**For the attention of Ms. Ellie Worth, Case Officer – Planning/Application reference number:  
2020/60/91015/W**

We write in reference to the proposed application for erection of 6 apartments adjacent to 13, Cuckoo Lane, Honley, Holmfirth, HD9 6AS by 3D Developments (Northern) Ltd.

CLIENT			
MRS K DYSON			
PROJECT			
PROPOSED APRTMENTS CUCKOO LANE HONLEY			
DRAWING TITLE			
PROPOSD SITE PLAN, FLOOR PLANS AND SECTION			
Rev.	Notes	Date	Drawn
A	Planning Revised to 3Flats	06.20	A.D.
SCALE	1:200@A1	03.20	A.D.
PROJECT No.	DRAWING No.	Rev.	
2020	02	A

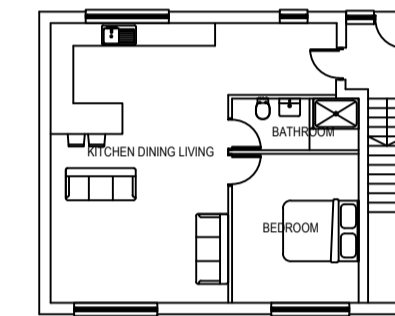
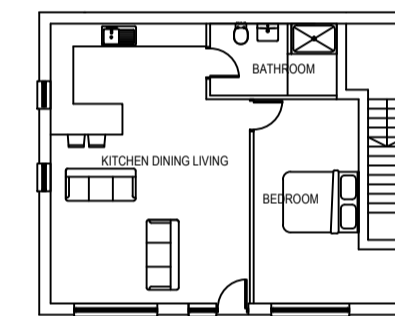
In addition, the proposal has totally inadequate parking provision to meet Kirklees Highways design guidance (being at least one parking space per 1 to 2 bedroomed dwelling) which means there should be provision provided for six parking spaces.

**The Residential Parking Standards** sets out the parking requirements for apartments at 1.5 spaces per dwelling. This planning application gives no parking provisions so how can this be right?

PROPOSED CROSS SECTION

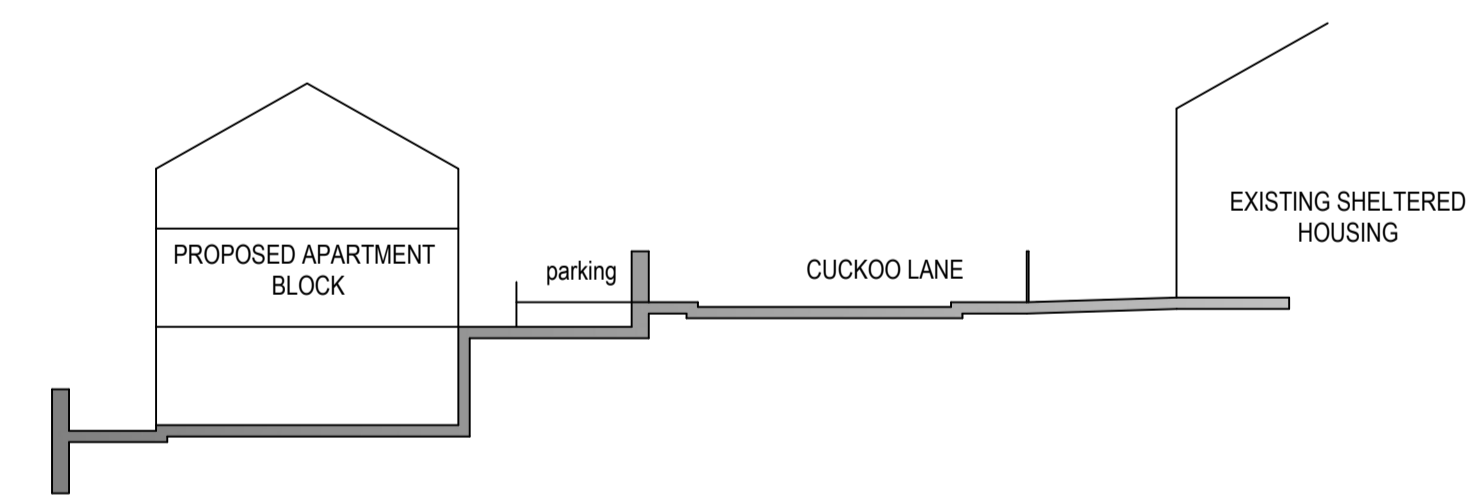
The proposed three storey property will be detrimental to the rights of privacy for the adjacent properties at the lower level to the South West of the plot and is contrary to Planning Policy Statements and Supplementary Planning Guidance PPS 7 A30. The direct overlooking of gardens will result in an intrusive, direct and uninterrupted view from a main room, to most areas of the gardens, which is often the main private sitting out area adjacent to the properties. As a general rule of thumb, this area is the first 3-4 metres of a rear garden, closest to the residential property.

From reviewing the submitted plans relevant to this application it is clear even this requirement is not being met.

The properties situated along Thirstin Road will be significantly overlooked by this large blot of a development on the landscape. Not only would this impact severely on the residents' privacy within their gardens but also within their homes too through the windows.

The proposed dwelling will also cause unacceptable levels of overshadowing to two longstanding character filled cottages. This will result in even more restrictions to the natural light entering the already darkened properties from the rear.

The proposal also fails to mention details on the matter of the ground engineering works necessary to ensure the existing embankment to the South West of the plot will be maintained and it is well documented that in previous years, work was carried out on the trees in this exact location has led to significant disruption of the dry stone wall to the rear of this site. Any significant work carried out on the land proposed for this new development will lead to major issues regarding the integrity of the very high banking and the safety and security of residents below.
